RE: BE/15/26/PL - Land East of Heath Place, Bersted, West Sussex, PO22 9SL: Environment Agency Position

We are writing in response to the initial EA comments on planning reference BE/15/26/PL, dated 02 April 2026.

Proposed Site Plan
1:200

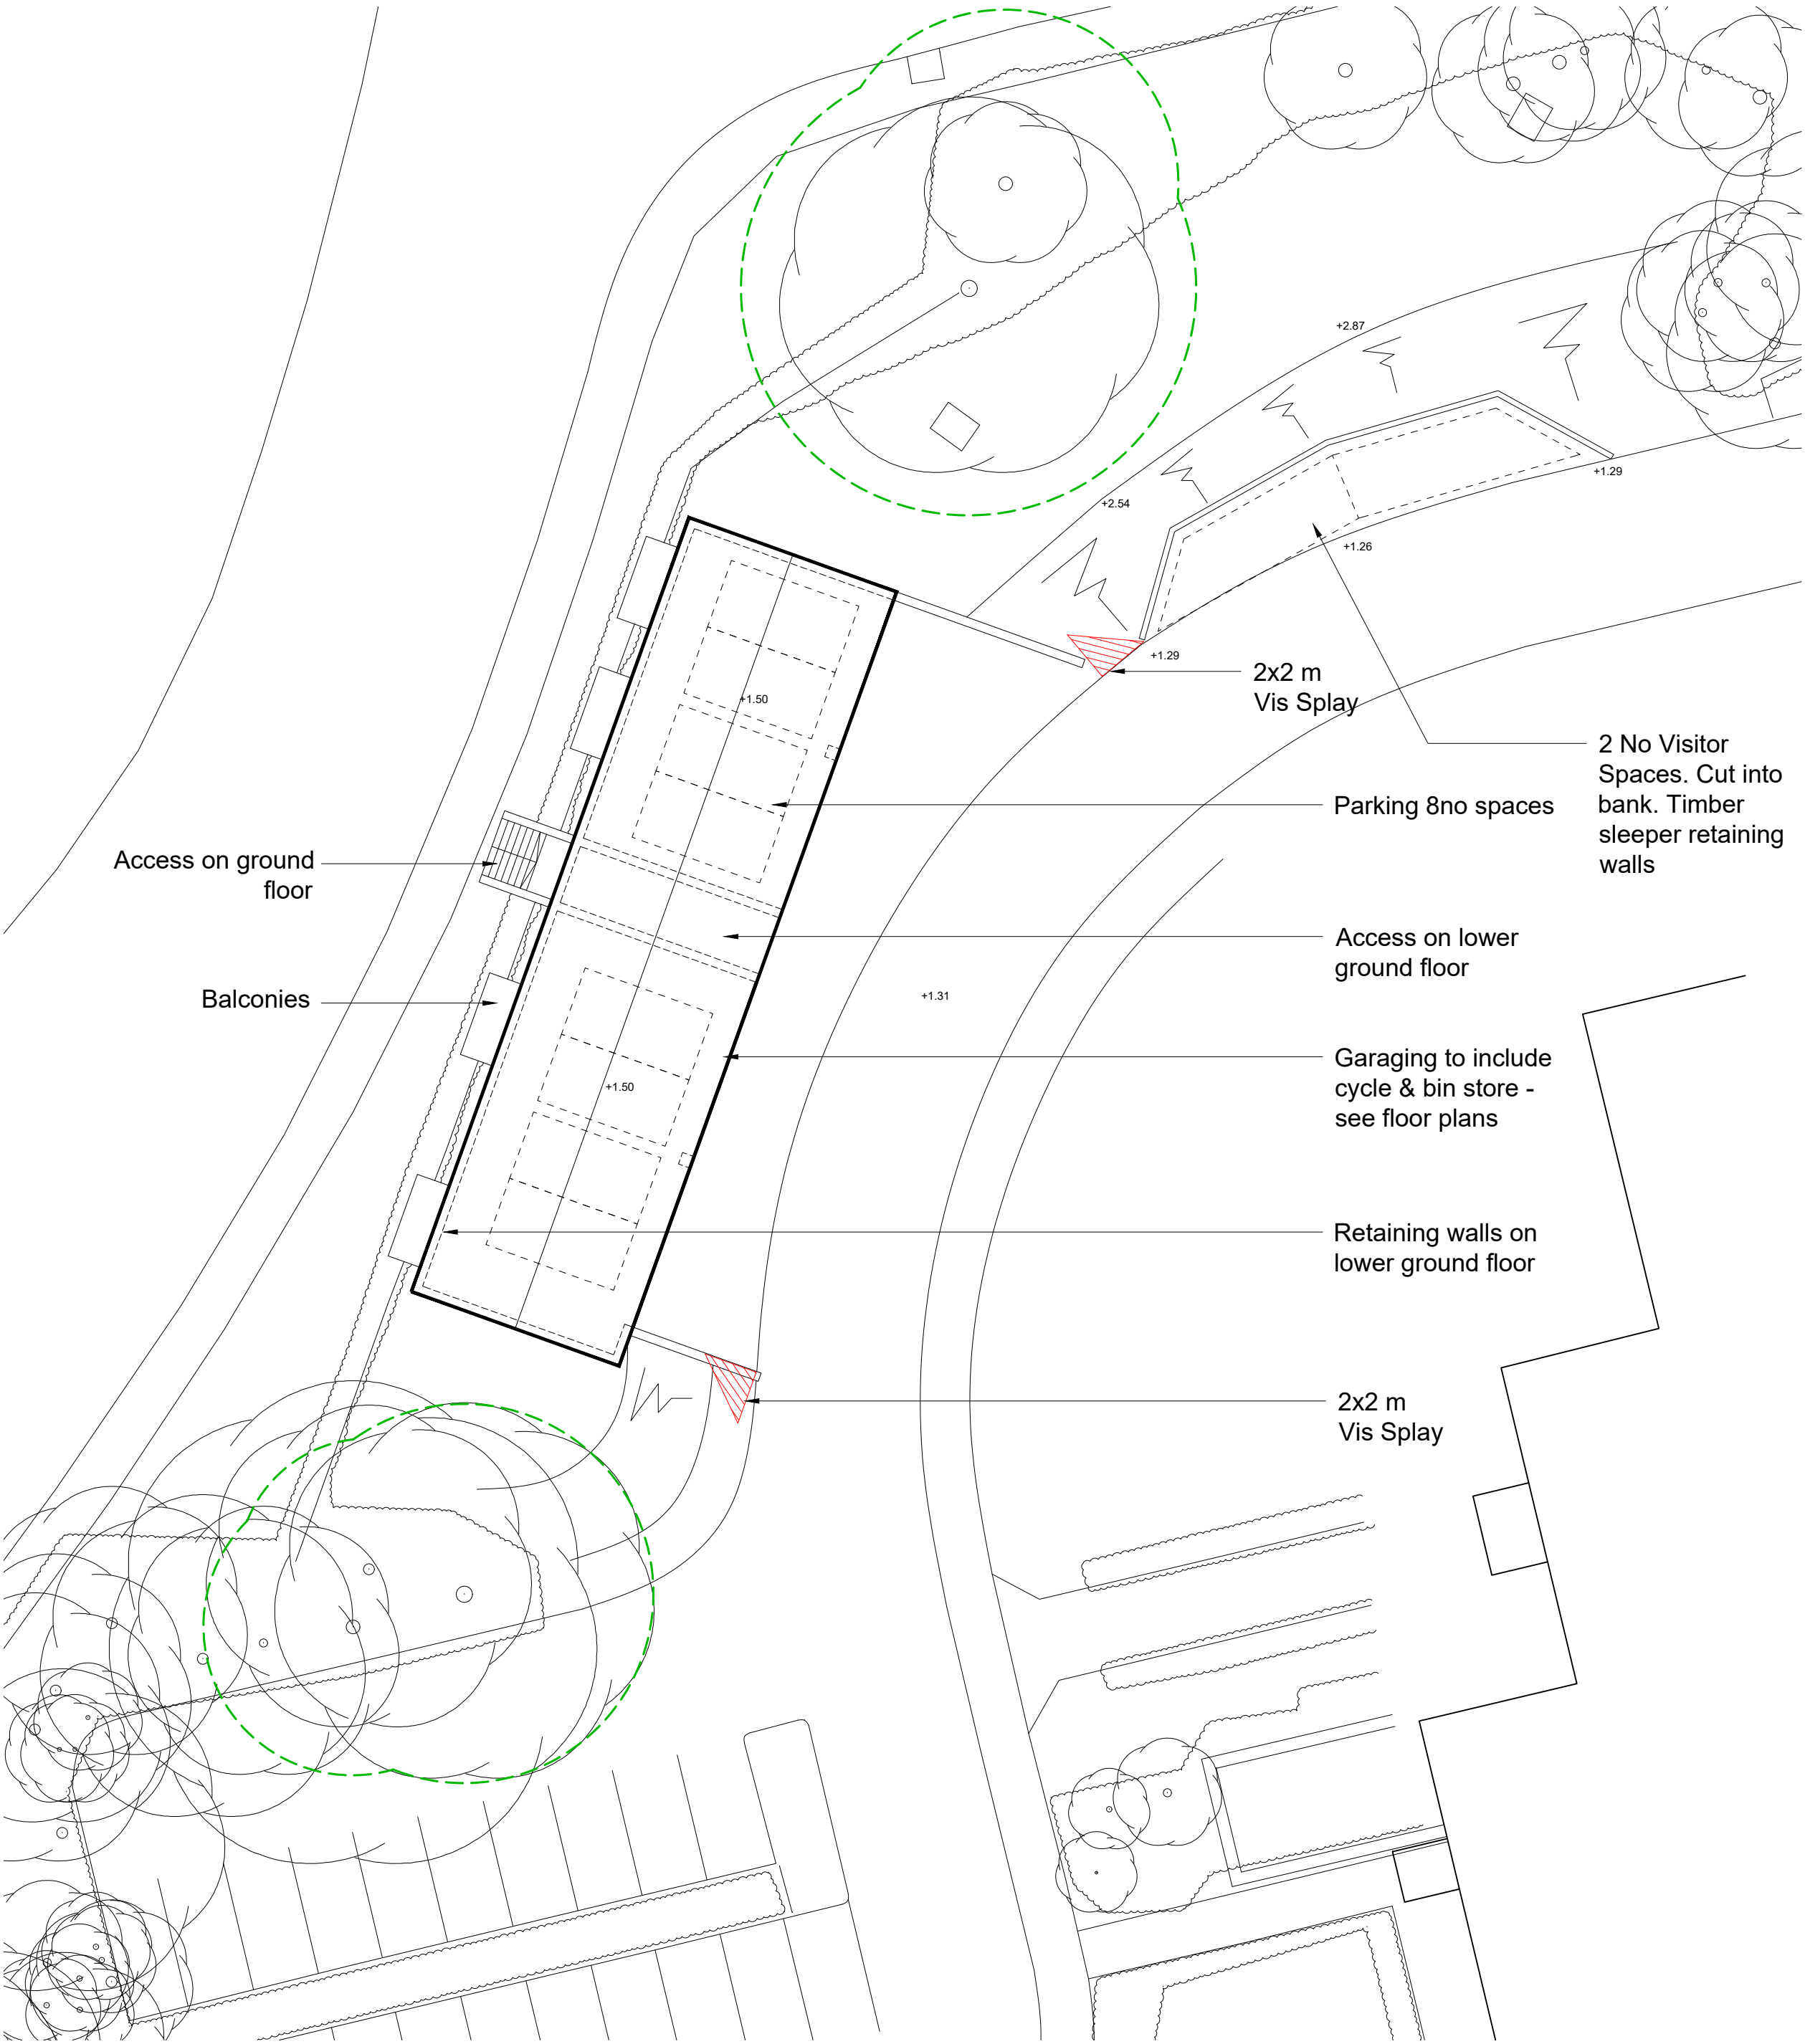
- *take the impacts of climate change into account:*
 - *Flood risk mitigation measures to address flood risk for the lifetime of the development included in the design are inadequate because they will not make the development resilient to the flood levels for the 0.1% AEP fluvial flood event. Consequently, the development proposes inadequate flood storage compensation.*

The use of under croft car parking at ground floor level has been proposed at other sites within the Aldingbourne Rife catchment area. Our local position is that, while in some cases they allow water to flow freely and will therefore not be classed as voids, they do not remove the need for floodplain compensation entirely. Therefore, loss of floodplain area to accommodate large supporting pillars/posts for these structures, should still be adequately compensated.

- The site is located on the edge of the floodplain and therefore there is no overland flow or flow pathway through the building. Water will rise on Heath Place and enter the site through the open front then recede the same way, as indicated by the purple arrows on the image below.

- The front of the building is largely open apart from two supporting pillars (totalling 0.45m²) and the stairwell.
- The car parking area is to be lowered to have a FFL similar to that of Heath Place (1.40m AOD) to allow car access. Currently, the land levels in this area are circa. 2.50m AOD.
- Therefore, as highlighted within the FRA already, levels are being lowered from outside the floodplain into the 1000 year floodplain – **which will increase floodplain capacity.**

- The car parking areas either side of the stairwell total 108m² and 90m². Lowering these two areas to 1.40m AOD will provide an additional 66.96m³ and 55.80m³ floodplain storage, respectively. (108x0.62=66.96. 90x0.62=55.80)
- The stairwell totals 23m² and the two supporting pillars in the front total 0.45m². Accounting for these within the floodplain calcs means 14.26m³ and 0.279m³ of flood water would be displaced.
- Overall, there will be an increase in floodplain capacity of approximately 108.221m³ during the 1000 year flood event.
- Given the significant increase in floodplain capacity, there is no additional requirement to provide additional compensatory flood storage on site.
